DECISION DELEGATED TO DEVELOPMENT MANAGER**DECISION DELEGATED TO DEVELOPMENT MANAGER**

Application No: H13-0392-21 **Applicant:** Mr L Salter

Proposal: Proposed double garage and games room/gym with annexe above and swimming pool extension

Location: 14a Broad Lane Moulton Spalding

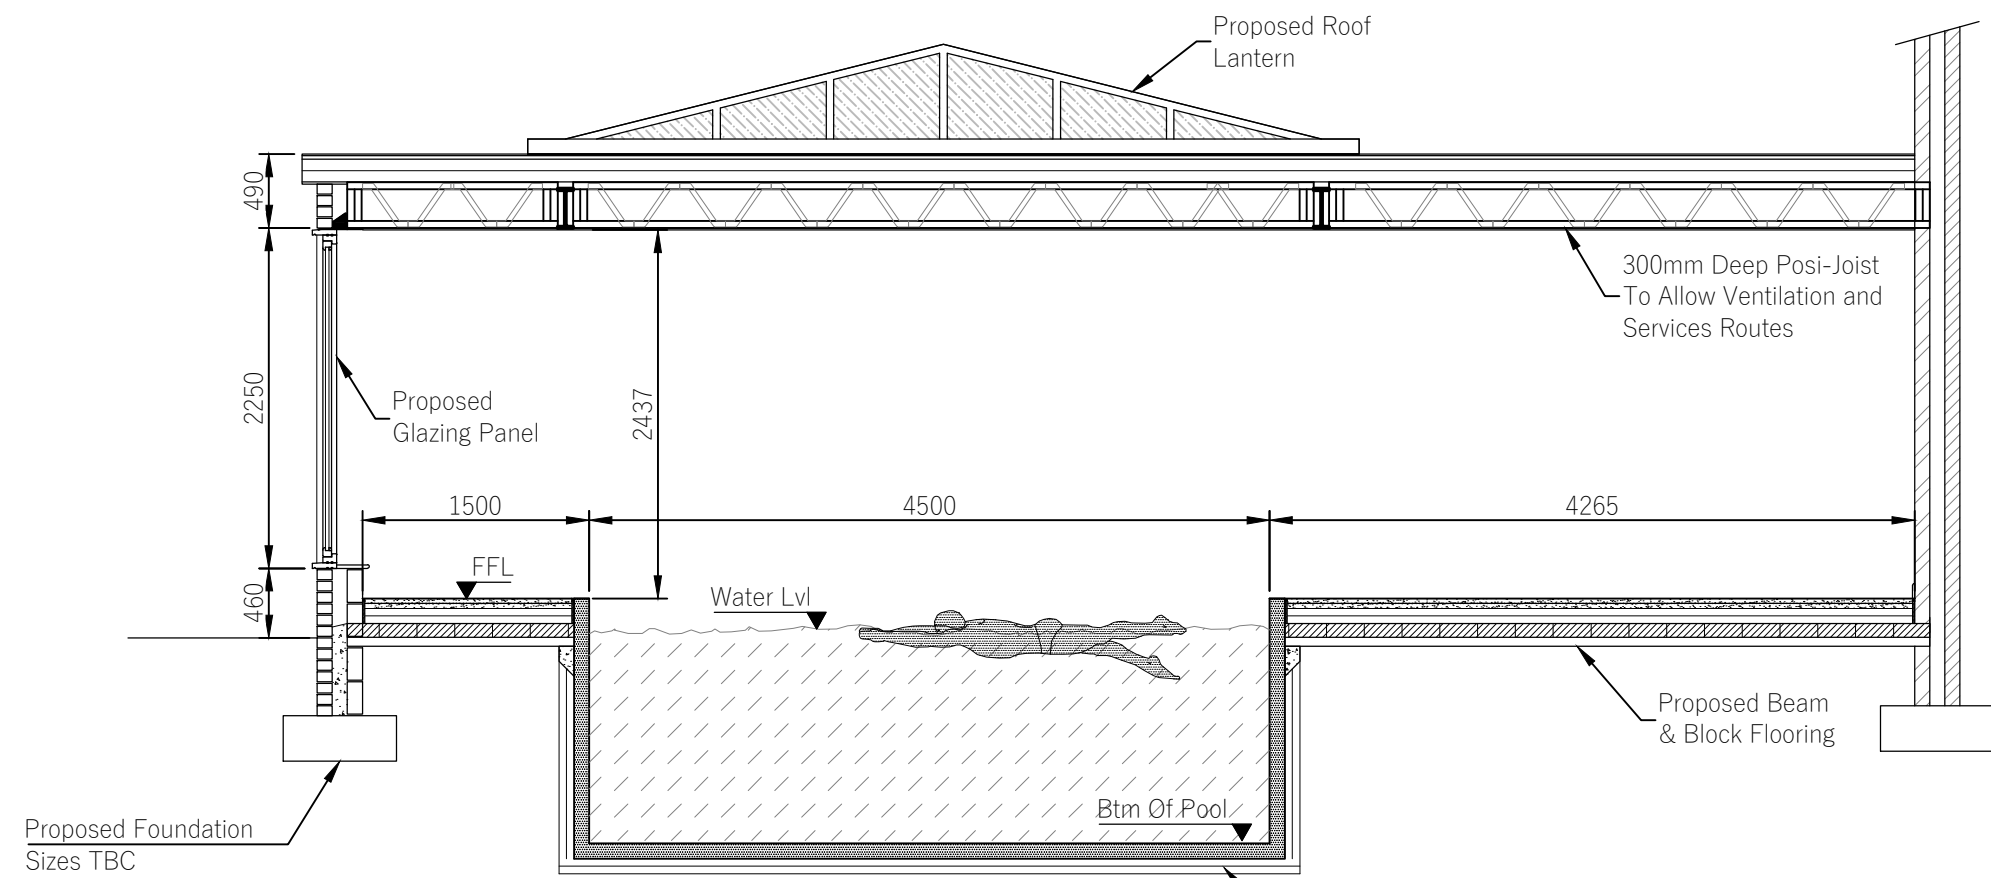
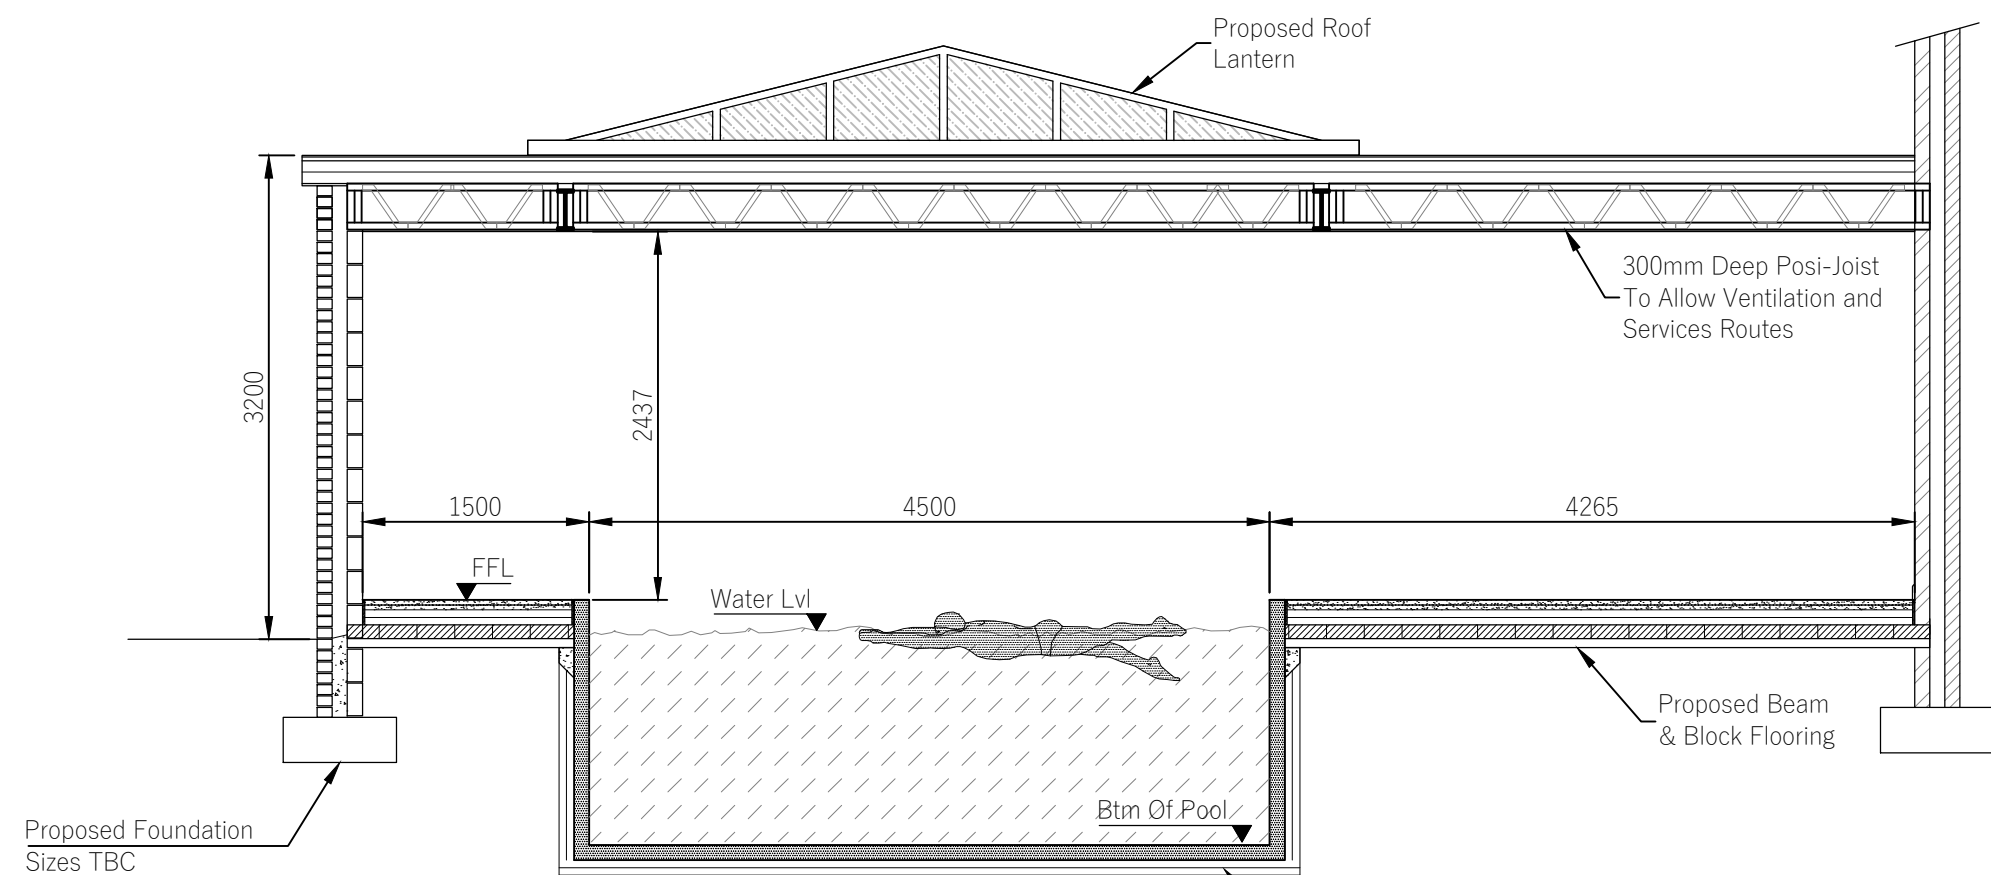
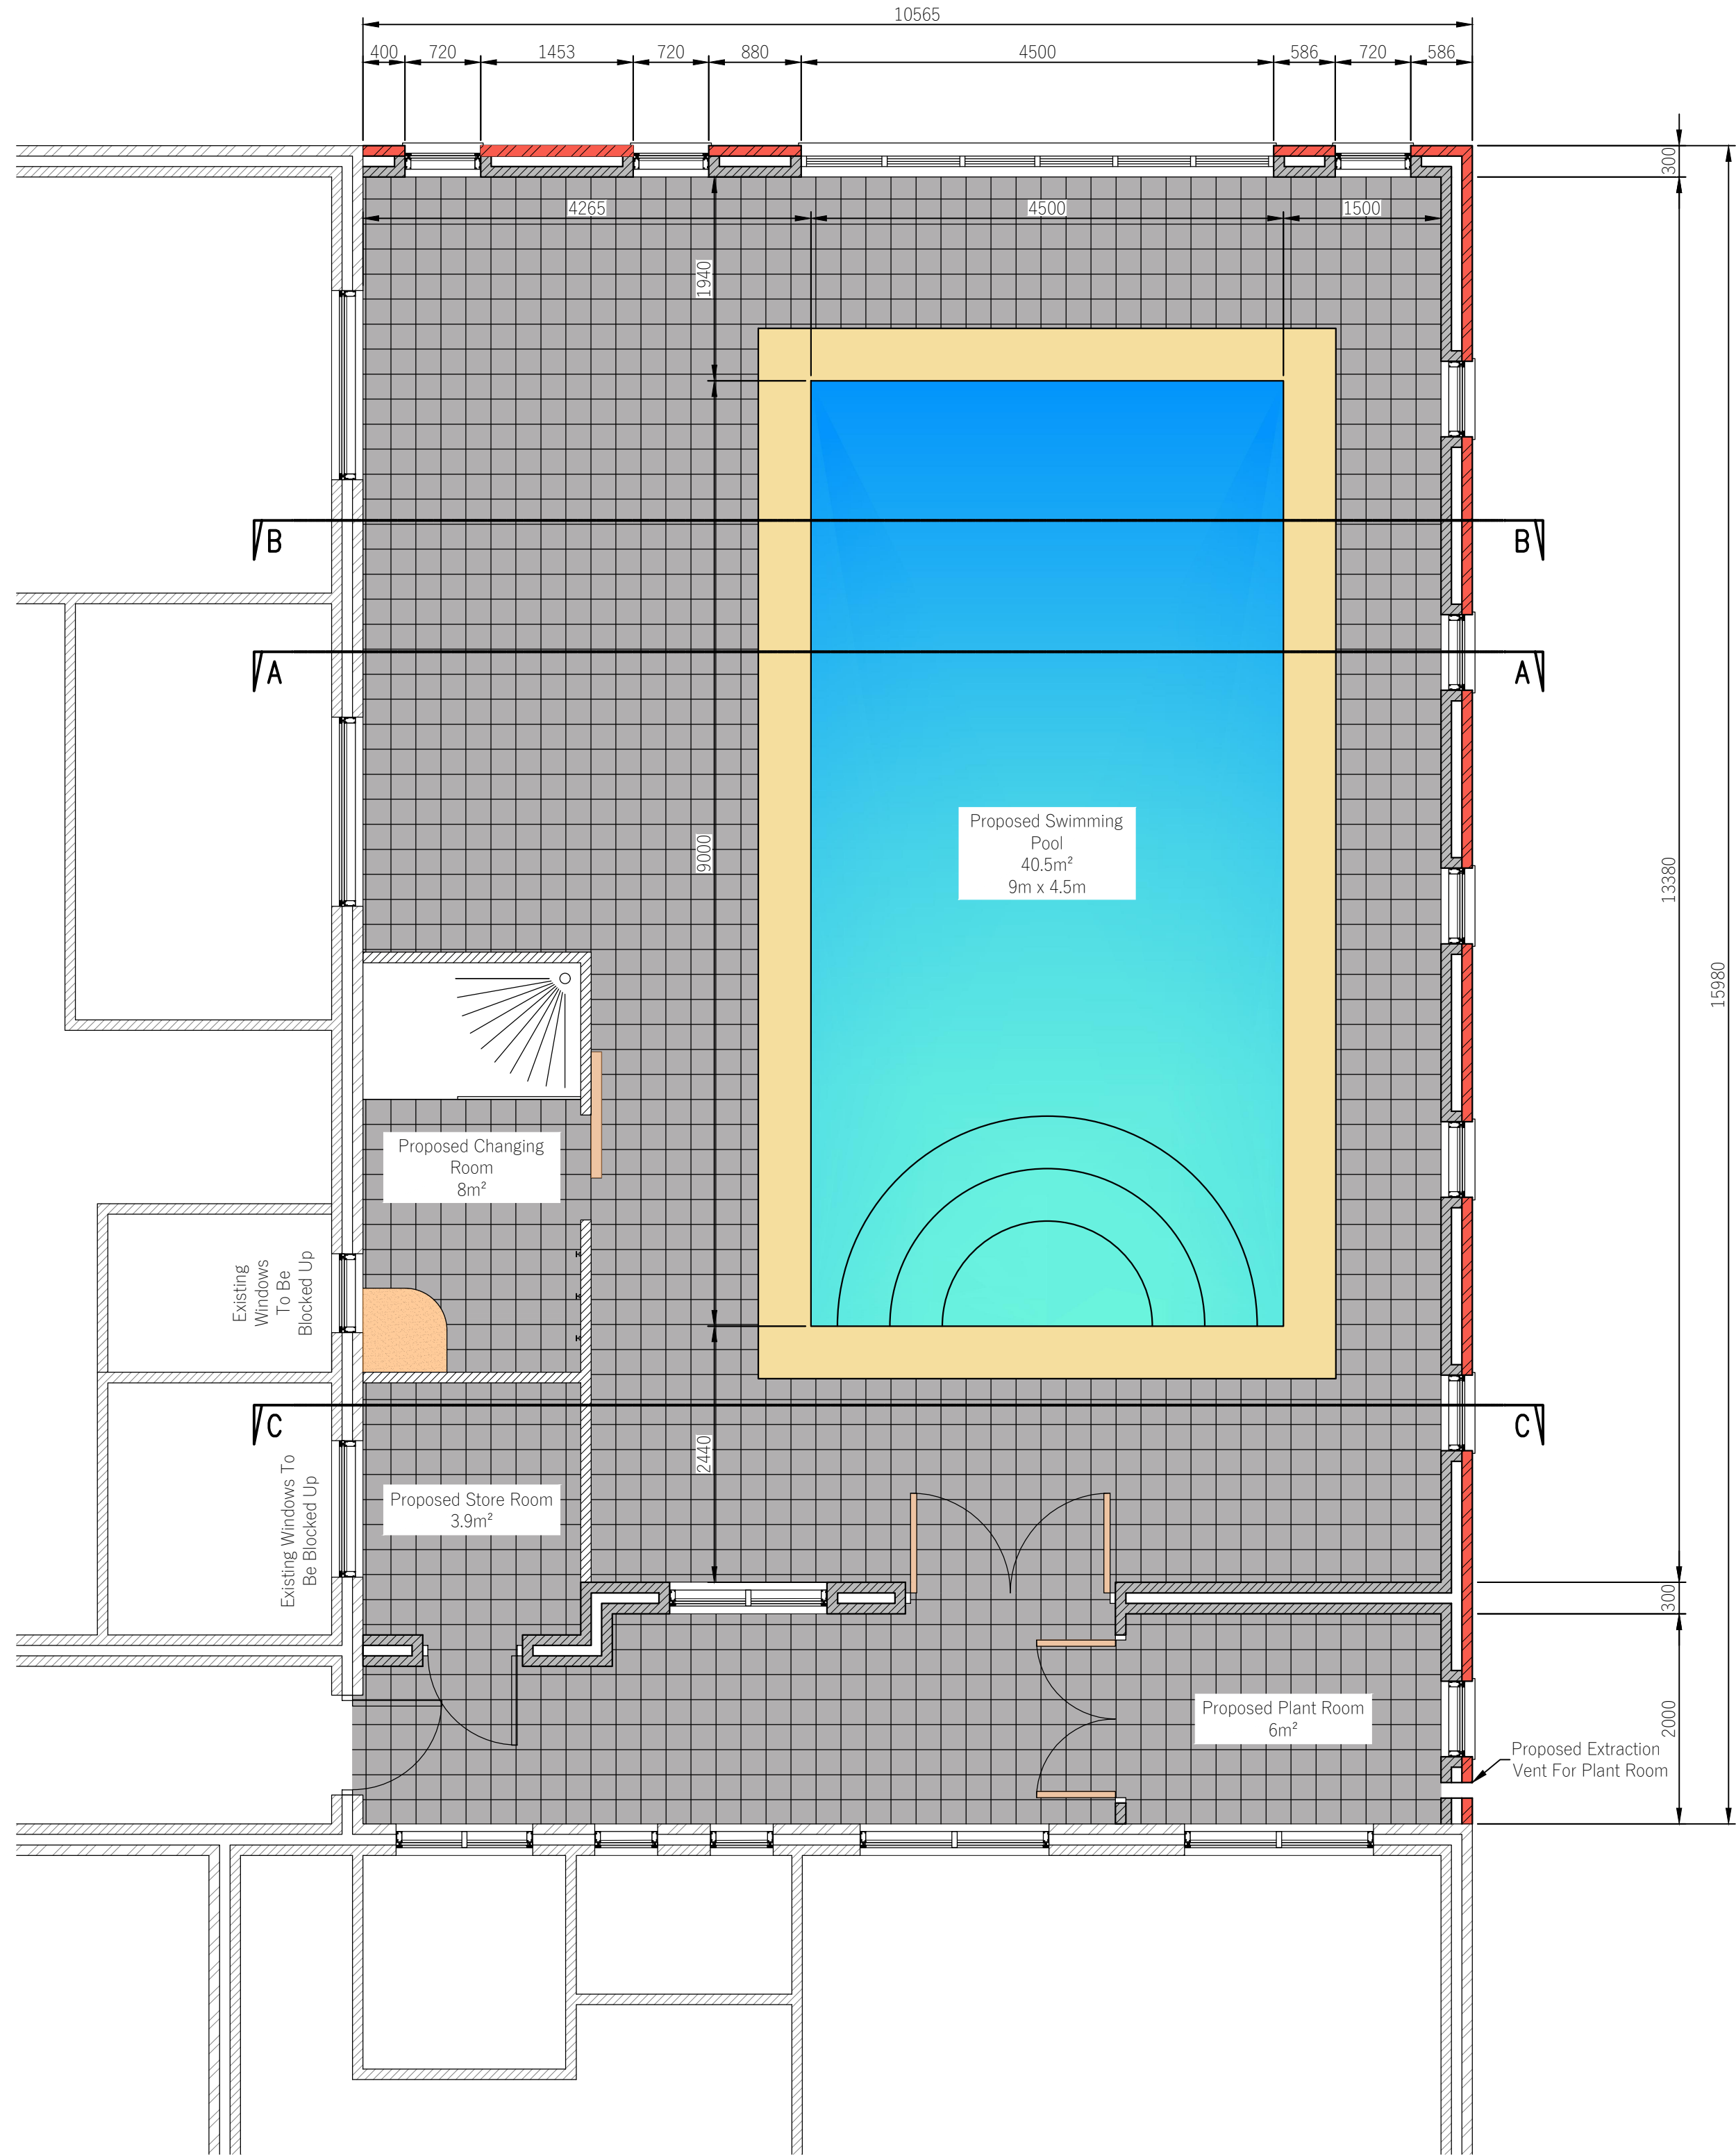
- Overshadowing from the pool structure
- Loss of privacy
- Noise and disturbance when the pool is being used
- Potential water damage from pool leakage
- Overhanging tree branches have been partially removed and it is understood that they will be removed altogether
- Concerns the pool may be used for commercial purposes

The adjacent neighbour at no.35 High Street has objected to the scheme siting concerns of overshadowing from the pool structure, loss of privacy and noise and disturbance when the pool is being used. The concerns are noted, however, given the domestic nature of the proposed pool and the fact it would be used in conjunction with the existing dwelling it is not considered that the noise/disturbance would be any different to what can be expected from a residential dwelling. The proposal would not create any new activities not already associated with the existing dwelling. With regards to potential overshadowing and loss of privacy resulting from the proposed pool extension it is not considered that there would be any unacceptable impact given the orientation of the property. The proposed structure would be sited close to the shared boundary with this neighbour, however given the fact this neighbour has a large rear garden, any overbearing impact immediately adjacent to the boundary can on balance be accepted.
